Consultation Response from KC, Conservation & Design**2024/91128 St Lucius Church, Butts Road, Farnley Tyas, Huddersfield, HD4 6TZ****Installation of solar panels and batteries (Listed Building within a Conservation Area)****Date Responded: 4.10.2024****Responding Officer: Sue Brooks****Responding Ref: KB 5/13**

SOUTH ELEVATION - 1:100

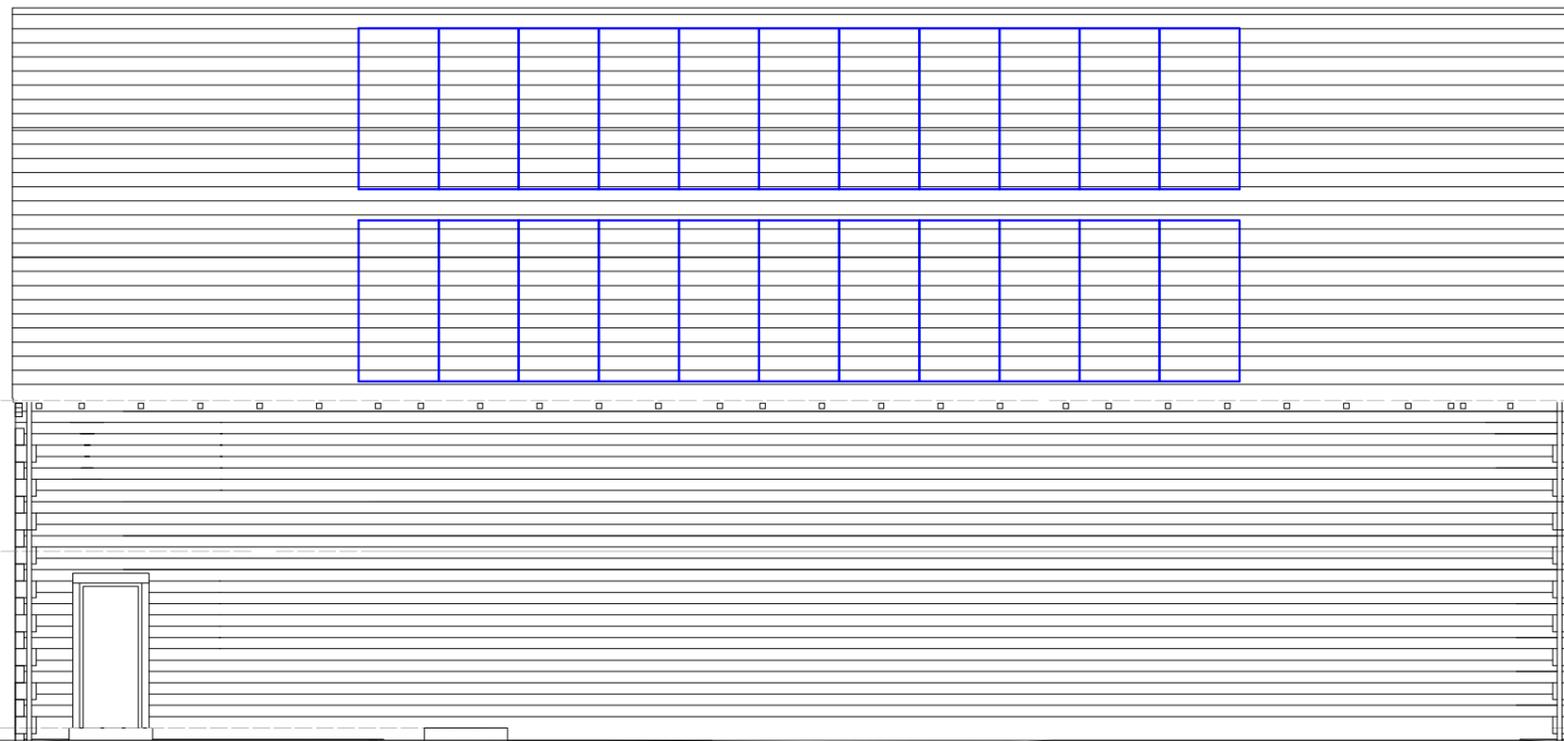
The application proposes a solar PV array of 22 black PV panels in two rows on the south facing roof pitch. These are fixed onto the existing stone slate roof covering with fixings that lap under the slates to avoid damage to the roof covering.

Given the visibility of the southern roof pitch during the winter months, the introduction of a large PV array on the south roof pitch of this large building will harm the character and appearance of the conservation area as black PV panels have very different characteristics to the existing roof covering in terms of size, finish, material and colour, and they do not replicate the look of traditional stone slates.

Given the prominence of the roof pitch during the winter months, the proposal is not considered to preserve or enhance the character of the conservation area, which is in a rural setting and can be

viewed from some distance.

The proposal is considered to lead to less than substantial harm to the significance of the conservation area by covering the existing roof with a prominent PV installation as discussed above. There are clearly public benefits in reducing energy costs in this community building and complying with climate change requirements. However, based on the information submitted we remain unconvinced that a PV array on this prominent roof is the most suitable option given the alternative measures outlined in the submitted reports. A balance needs to be made between the harm to the conservation area and the public benefits of the proposal. The supporting documents investigate various energy saving measures, and as alternative measures including ASHP's and internal improvements have been recommended we feel that the justification for a large PV array is not convincing. On balance, we do not feel that the public benefits outweigh the harm and would suggest that alternative options are explored further.
